December 12, 2018

**RE: Townhome for Jason Buchanan
1106 Griegos NW
Grading and Drainage Plan
Engineer's Stamp Date: 12/6/18
Hydrology File: F14D058A**

Based on the submittal received on 12/7/18, the Grading and Drainage Plan cannot be approved until the following are corrected:

TOWNHOME FOR JASON BUCHANAN
1106 GRIEGOS RD., NW
GRADING AND DRAINAGE PLAN

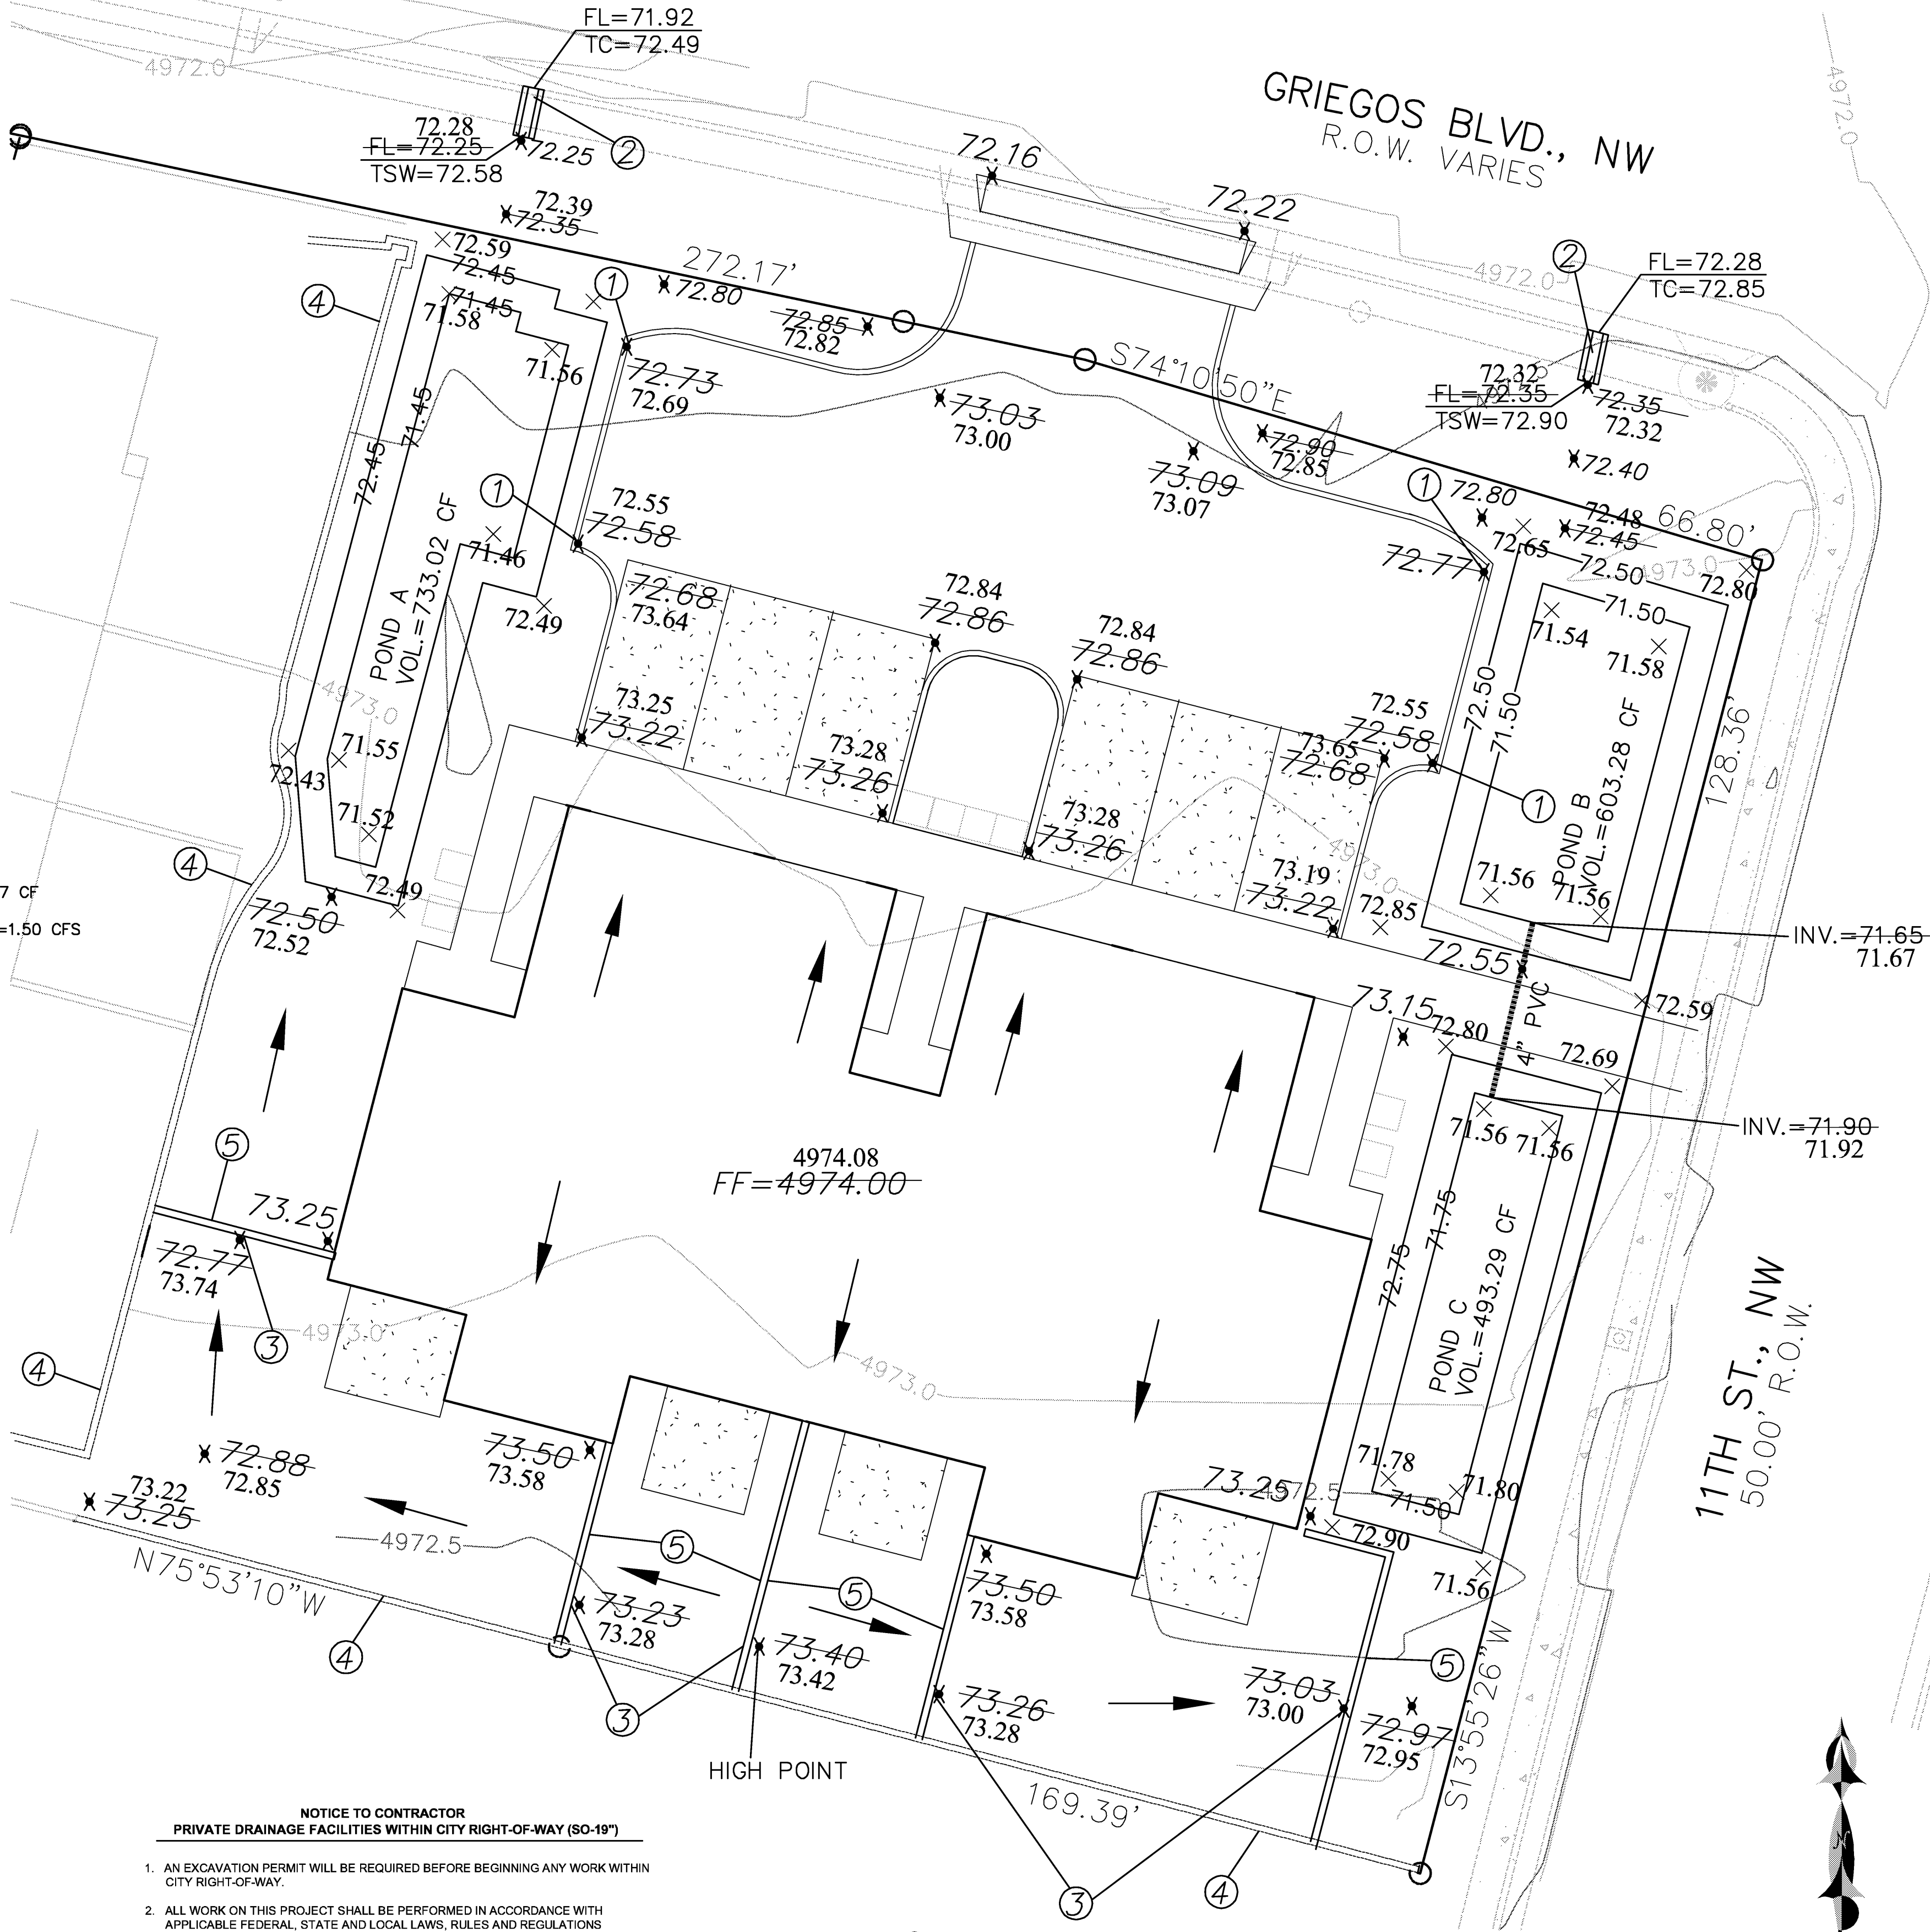
1. The site must demonstrate adequate downstream capacity per § 14-5-2-12(G) of the Albuquerque Code of Ordinances.
2. The unofficial policy of allowing 2.75cfs/acre discharge in the Valley is no longer accepted. Sites must demonstrate downstream capacity or pond the increased runoff onsite. Remove all references to the 2.75cfs/ac allowance. This site does not appear to discharge to the ROW, therefore onsite ponding of the 100-yr, 6hr storm is likely required. Part of the North portion of the site may drain to Griegos, but this needs to be delineated and quantified if attempting to match some historic discharge rate.

3. Under "Calculations" reference is made to the AHYMO input and summary files, but none are provided.
4. The existing survey needs to be supplemented with spot elevation due to the lack of elevation relief here.

5. Include flowline and top of curb elevations along Griegos at the curbcut and sidewalk culverts. Provide a waterblock, 0.87' high, at the entrance. Ensure impervious runoff from the site gets routed into the stormwater ponds and doesn't simply flow out through the entrance.

6. Define existing vs. proposed walls; do not place additional fill against existing walls. The existing wall on the west side of the site has an odd meander; will it remain or be rebuilt?
7. The “Notice to Contractors” notes are duplicated. Also, include the [standard SO-19](#) notes on the grading plan and callout the sidewalk culverts to be constructed by SO-19 permit.
